From: Brian Elstone [REDACTED]
Sent: 30 May 2022 14:14
To: Harry Chalk <Harry.Chalk@arun.gov.uk>
[REDACTED]
Subject: RE: LU/93/22/PL - Description Clarification.

From: Harry Chalk <Harry.Chalk@arun.gov.uk>
Sent: 30 May 2022 13:18
To: Brian Elstone [REDACTED]
Cc: Juan Baeza <Juan.Baeza@arun.gov.uk>; Anita Gardner <Anita.Gardner@arun.gov.uk>
Subject: LU/93/22/PL - Description Clarification.
Importance: High

I've been going through the submitted documents and have noticed that the description may not accurately reflect the proposal. I note that the description currently reads 'Replacement of 43 No. existing timber windows with new double glazed PVCu windows. This application is in CIL Zone (Zero Rated) as other development.'

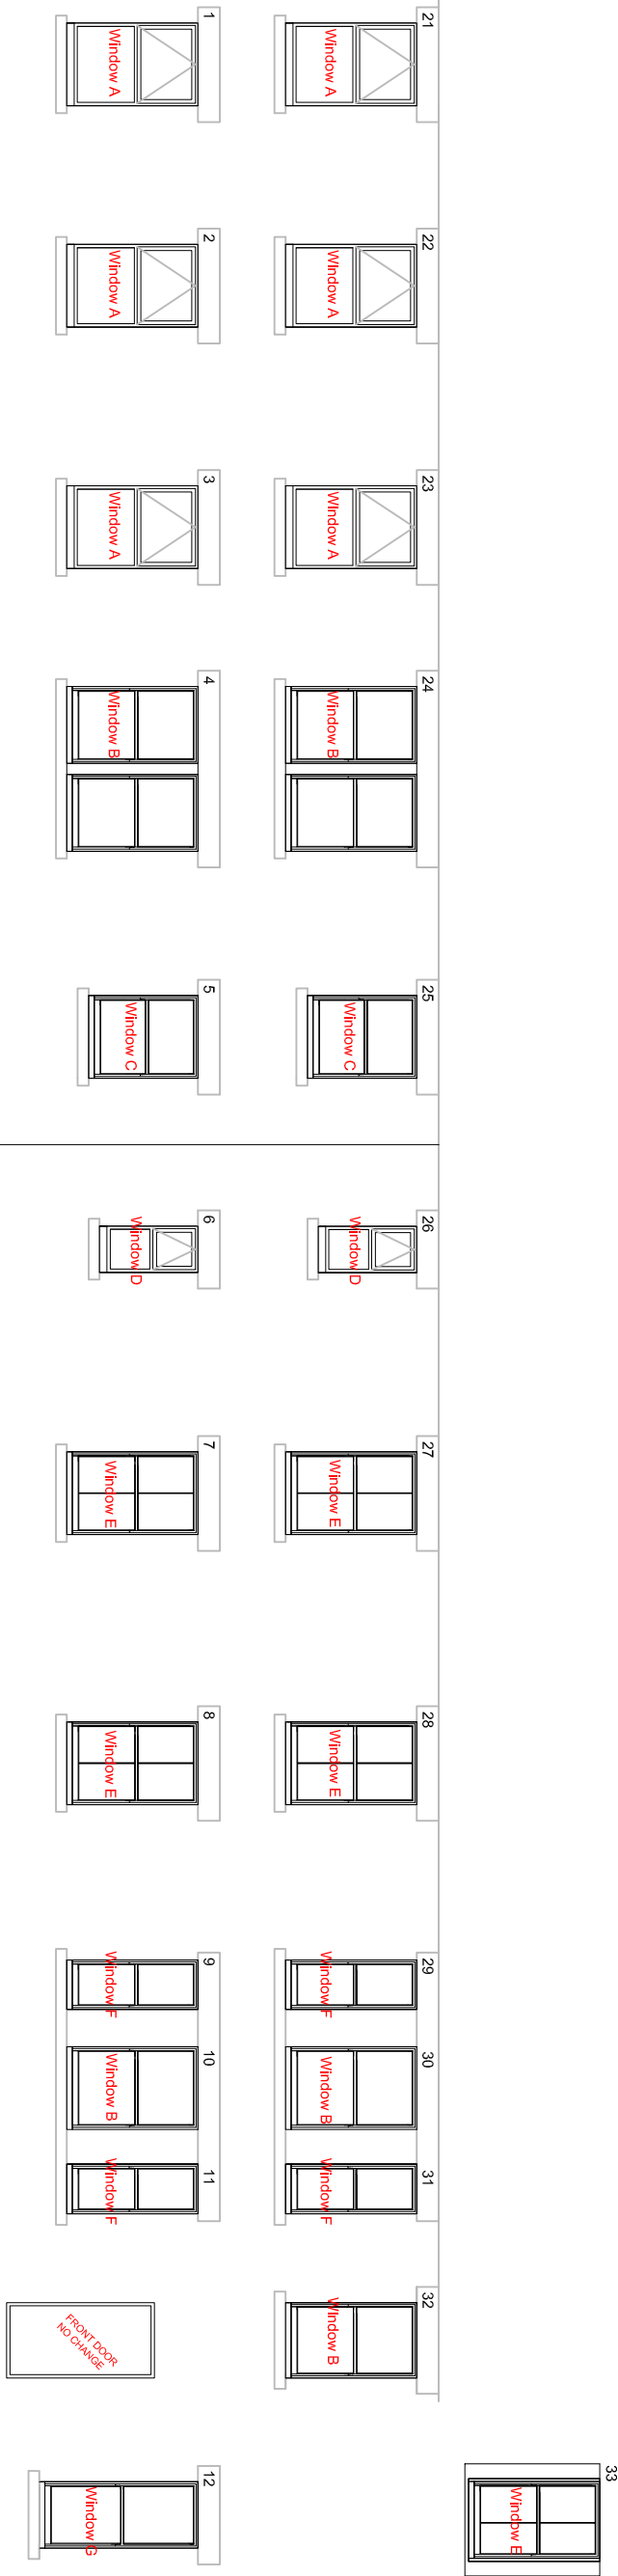
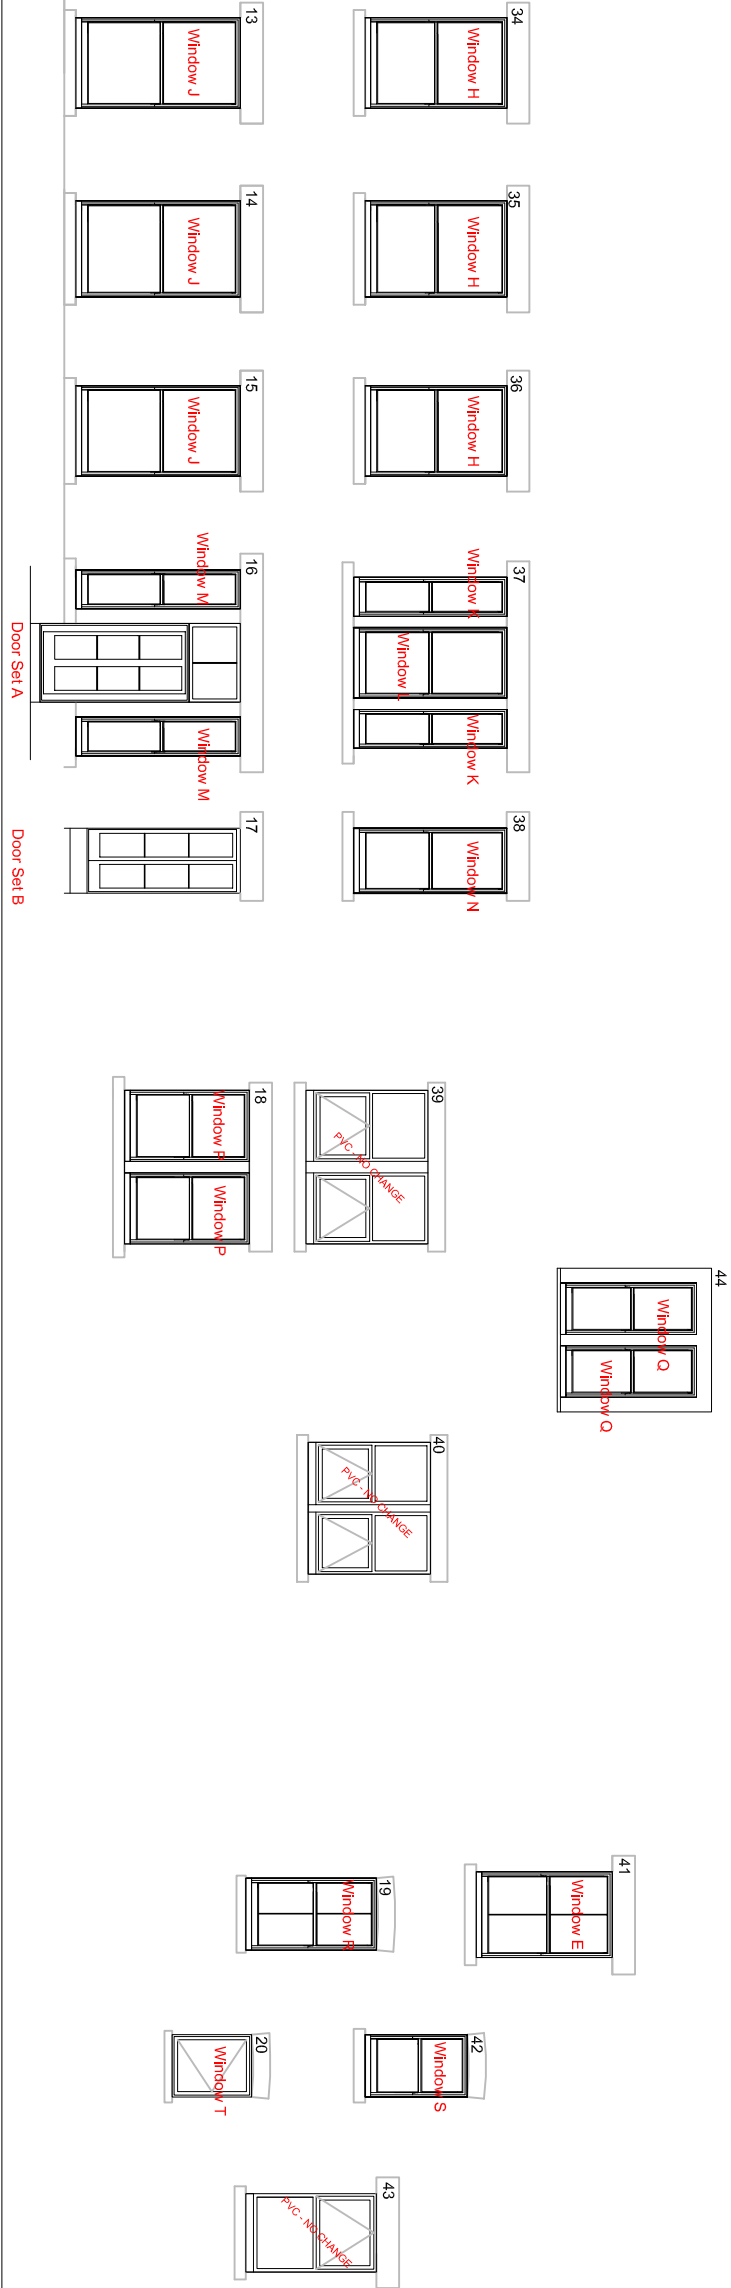
The elevational sheet appears to show that 3 of the total 43 No. windows are labelled as 'PVC – No Change' and the application form description only regards replacement of existing timber frame windows.

Could you confirm if the description would better read as 'Replacement of 40 No. existing timber windows with new double glazed PVCu windows. This application is in CIL Zone (Zero Rated) as other development.'?

Yes you are correct in this. Only 40 windows to be replaced. Sorry for any confusion, although those already replaced may not have had permission.
